Reviewed for Code Compliance

07/01/2024

2018 APPENDIX B - BUILDING CODE SUMMARY FOR ALL COMMERCIAL PROJECTS

SHEET NO.  
**E2**

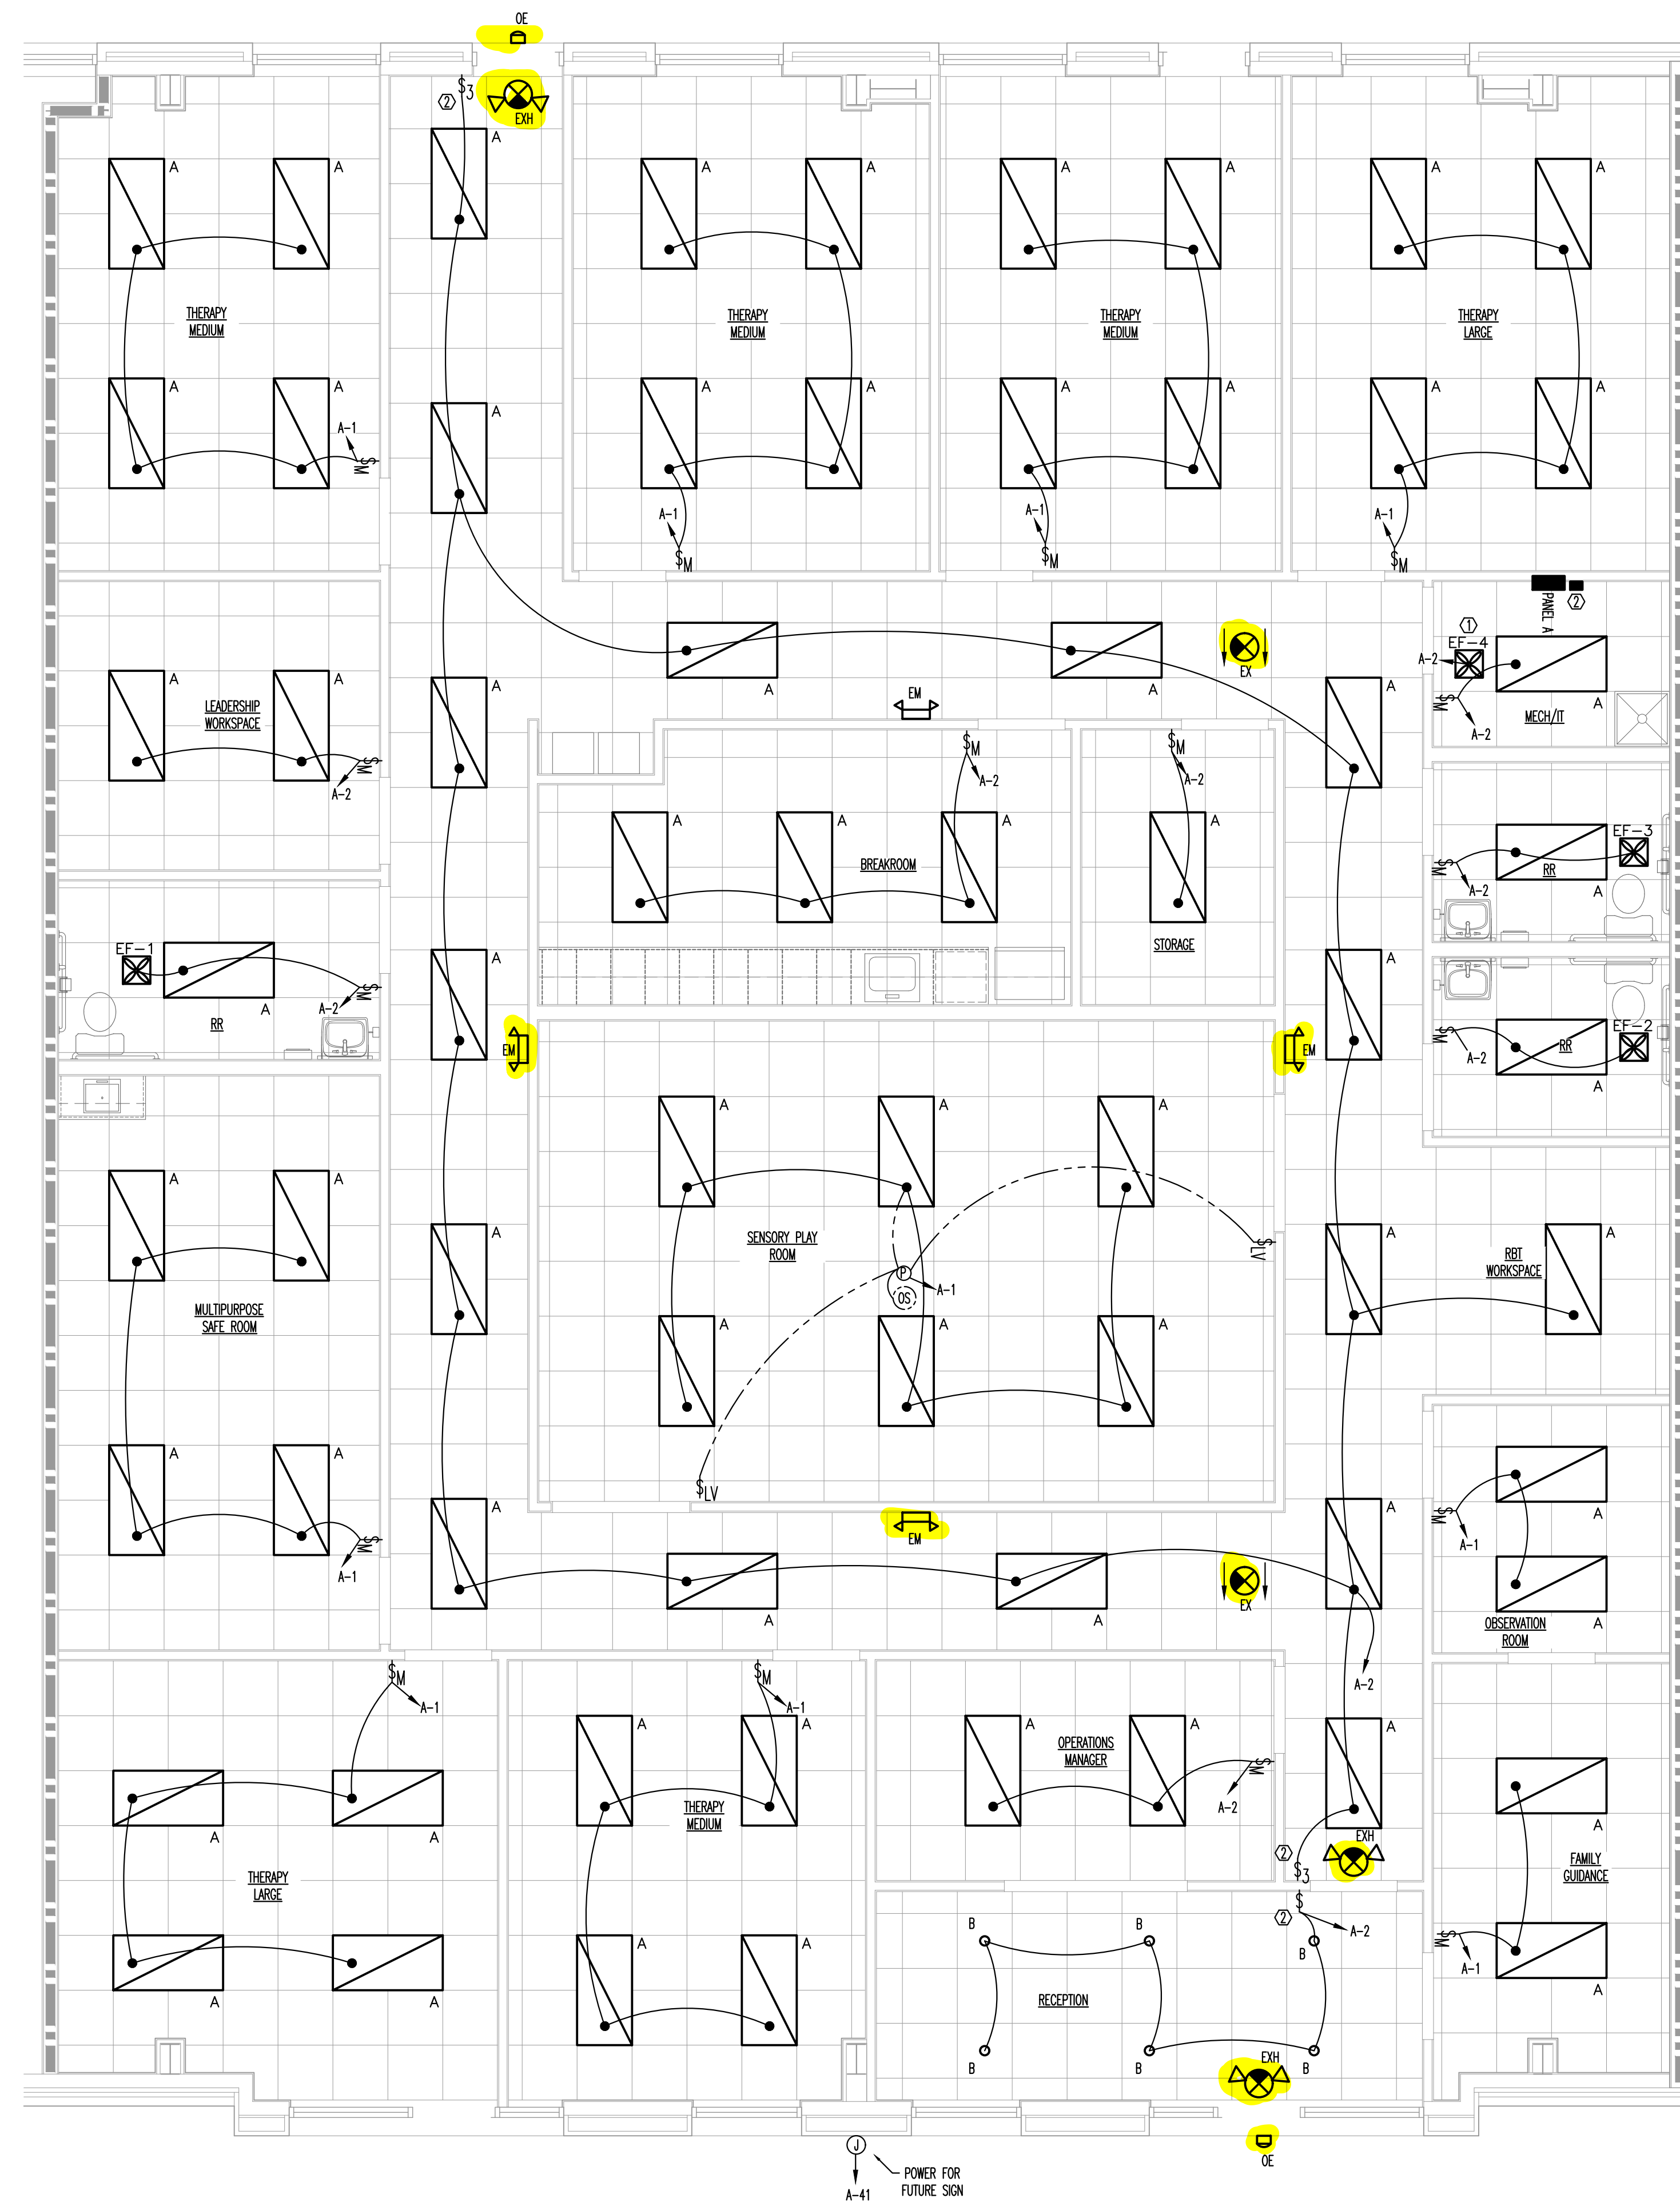
All receptacles at 48" AFF and below shall be Tamper resistant
